Sir Antony Gormley and Antony Gormley Studio

Submission for Deadline 9 – 8th July 2020

Highways England Responses to The Examiner’s Third Written Questions

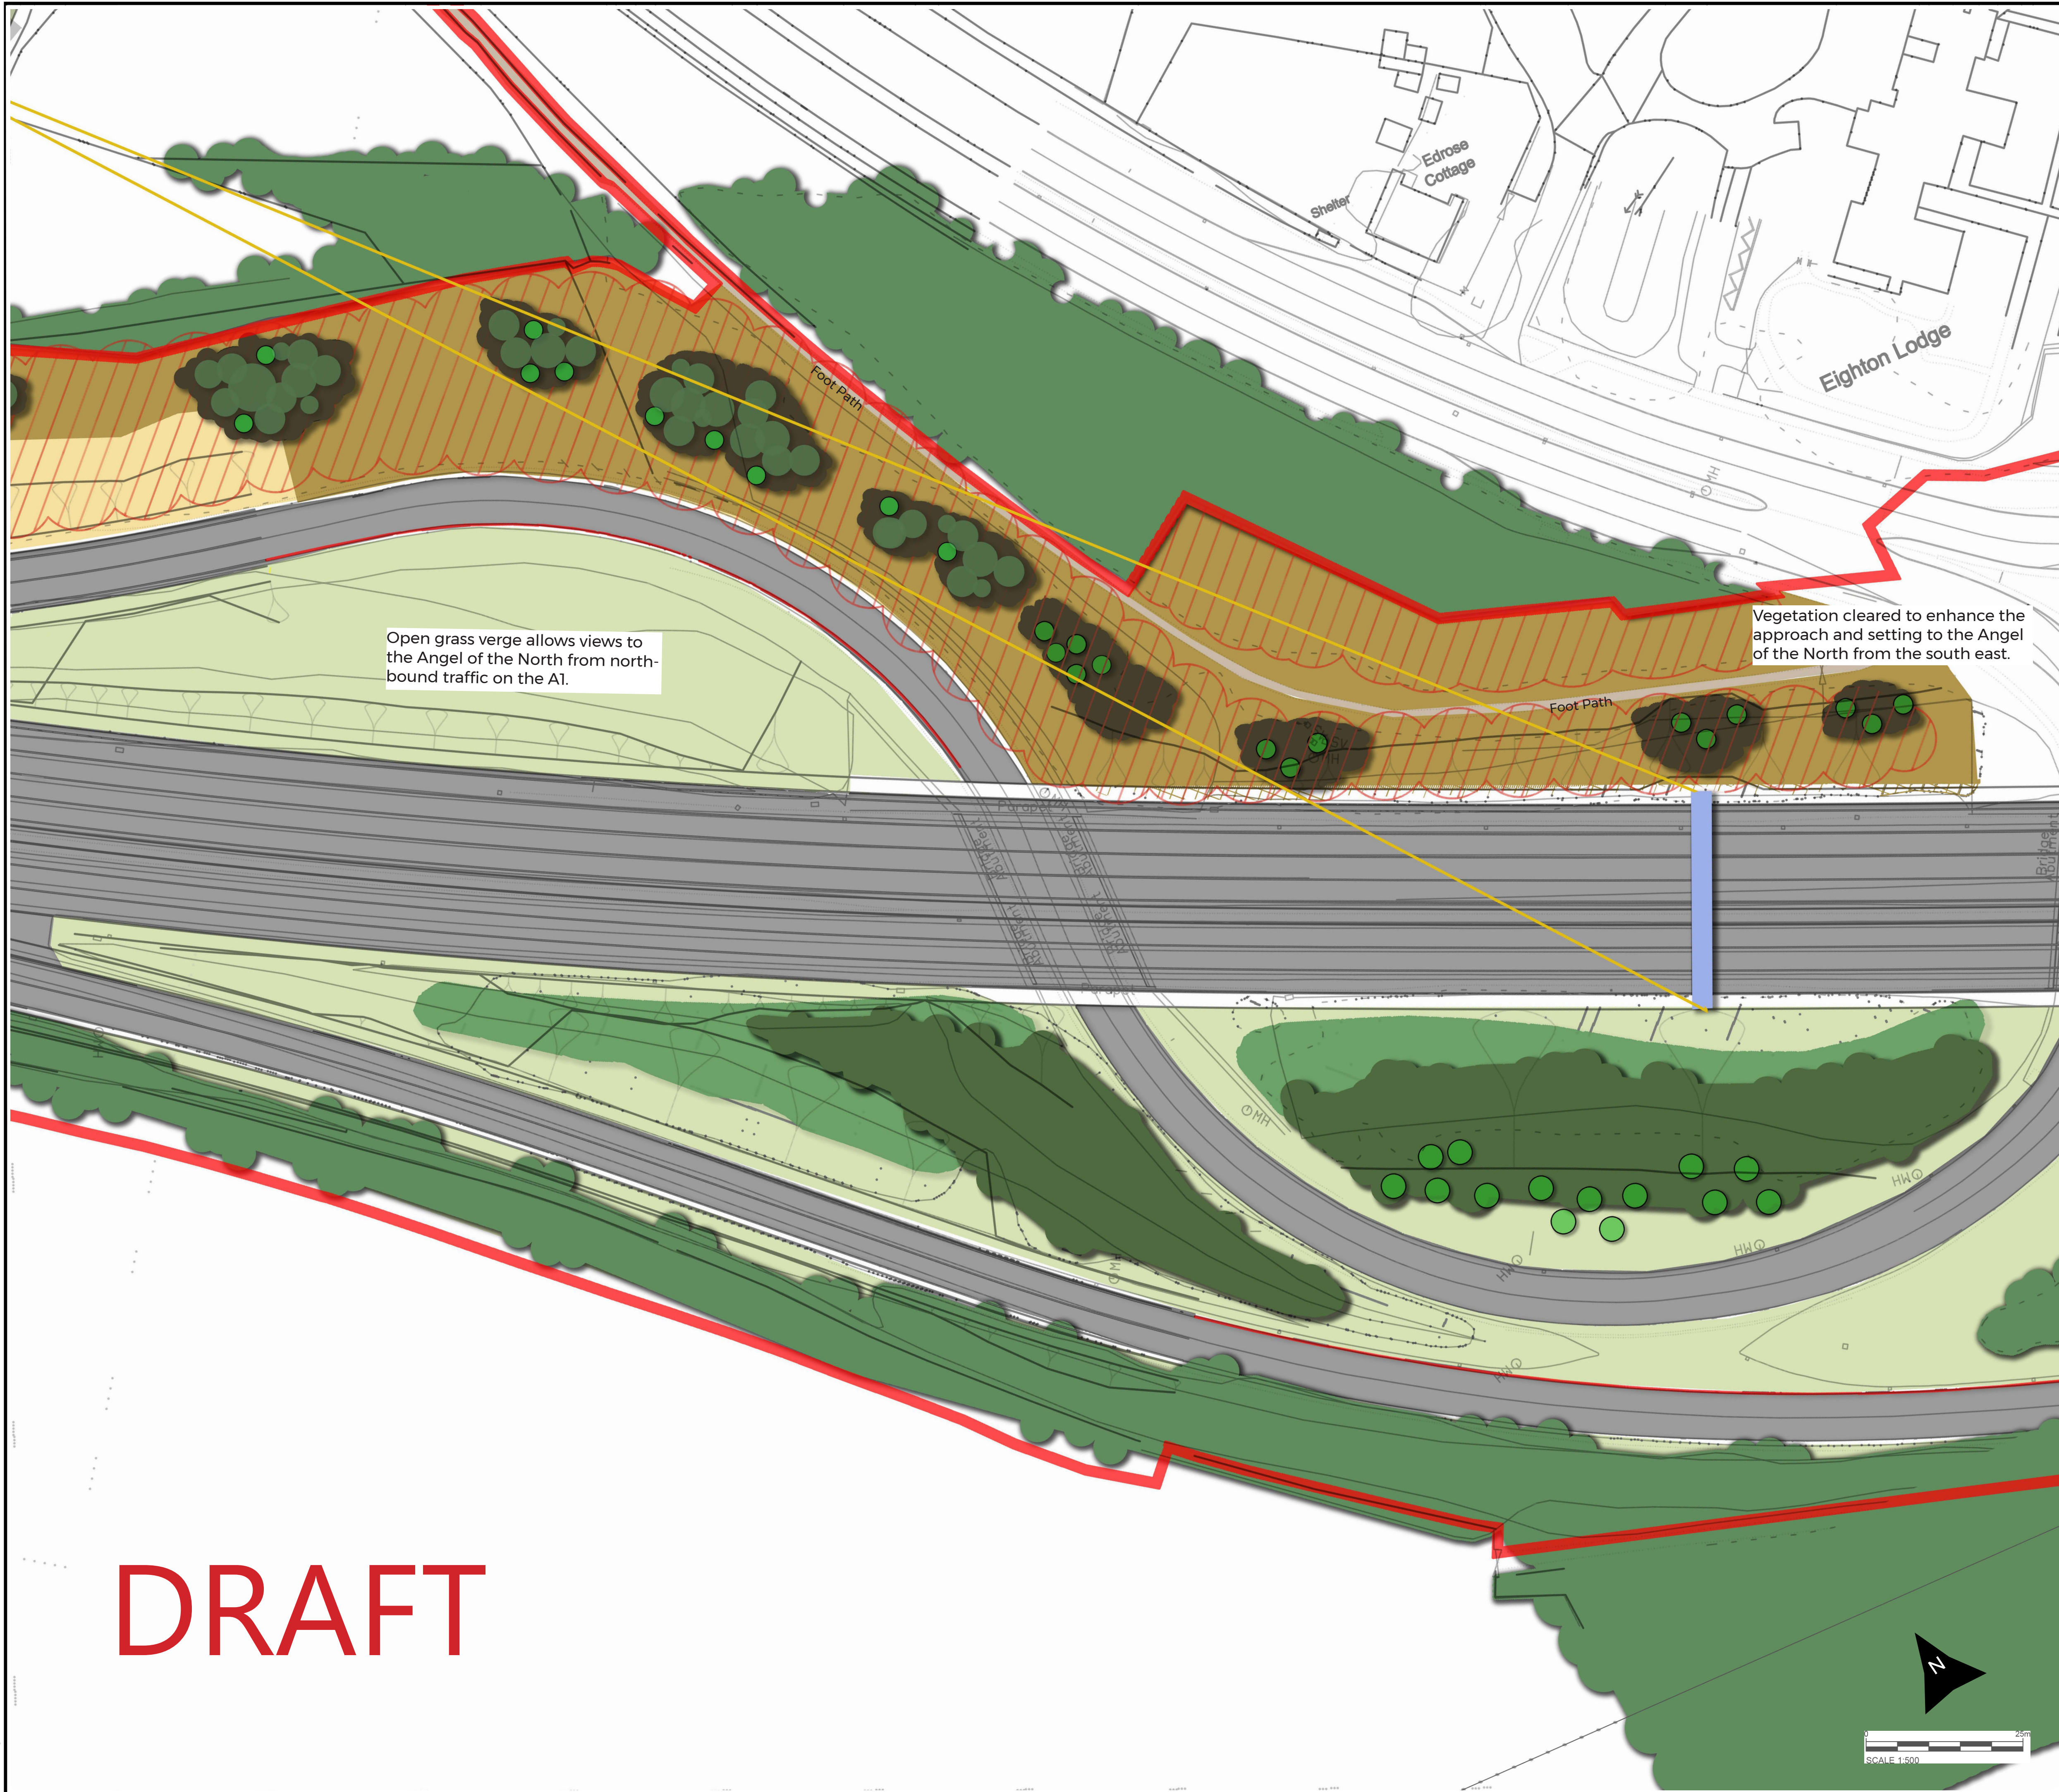
CH1 – Sir Antony welcomes the thinning of vegetation creating a less dense visual barrier and emphasises the need to work closely with Gateshead Council to develop a coherent scheme.

L8 – We would support the Applicant’s approach of scattered planting to allow greater awareness of the Angel of the North, however we would like further details on the proposed species of vegetation in each area.

L14 – Again, Sir Antony would support the thinning of vegetation to allow greater visibility of the Angel of the North.

Sir Antony's main interest is that the mound should be visible, and any vegetation that remains along any of the key views of the Angel of the North should be shrub-like and therefore low lying.
